## Application for Removal or Variation of a Condition following Grant of Planning Permission or Listed Building Consent

Demolition of existing dwelling and erection of replacement dwelling and detached garage, associated landscaping and driveway alterations

23/01854/FUL

Based on current Planning Approval 23/01854/FUL

Title
 Roof Plans

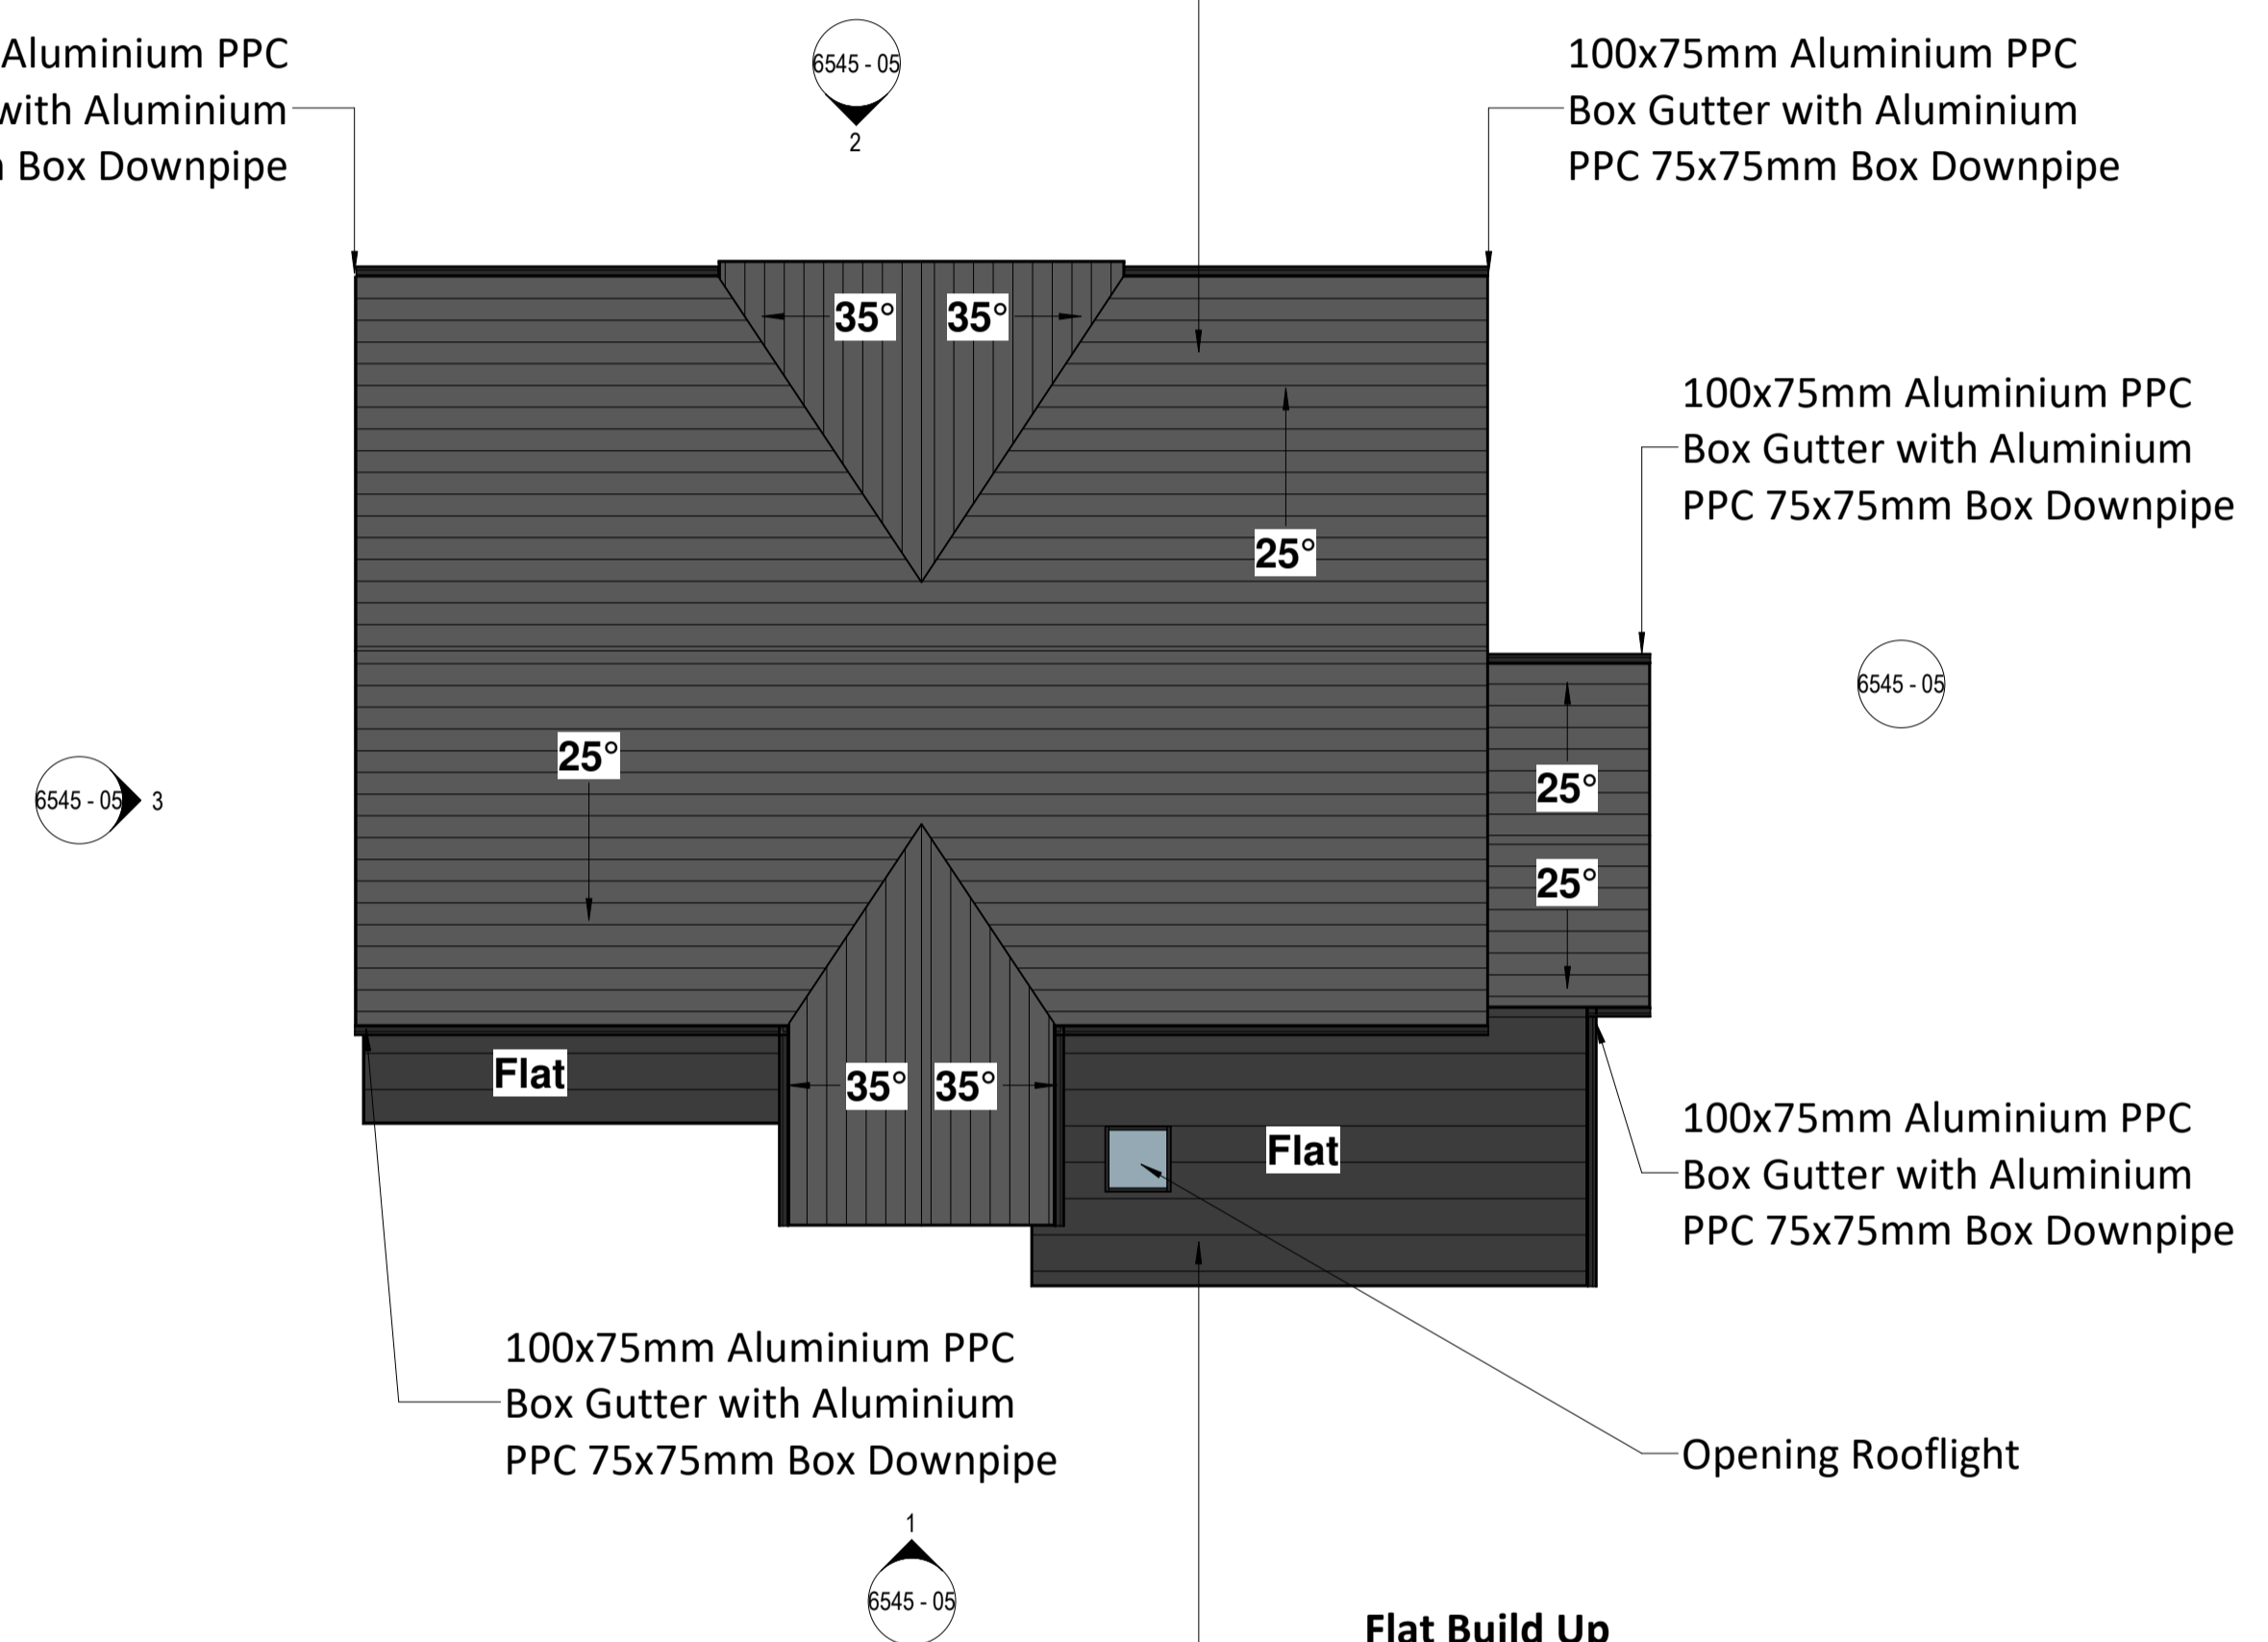
Condition 2 - Some windows made smaller on side elevation, an outside door added to plant room, minor internal floor plan changes and fewer glass panes in two windows but no size increase, plus opening roof light added to flat roof w.c.

Condition 2 - should just say that 'the development hereby approved should be carried out in accordance with the revised plans submitted with the application.' In this instance, this covers the following revised drawings, which are attached to this application:

- 1) Proposed Site Plan (6545-02 Rev D)
- 2) Floor Plans (6545-03 Rev D)
- 3) Roof Plans (6545-04 Rev D)
- 4) Proposed Elevations (6545-06 Rev D)
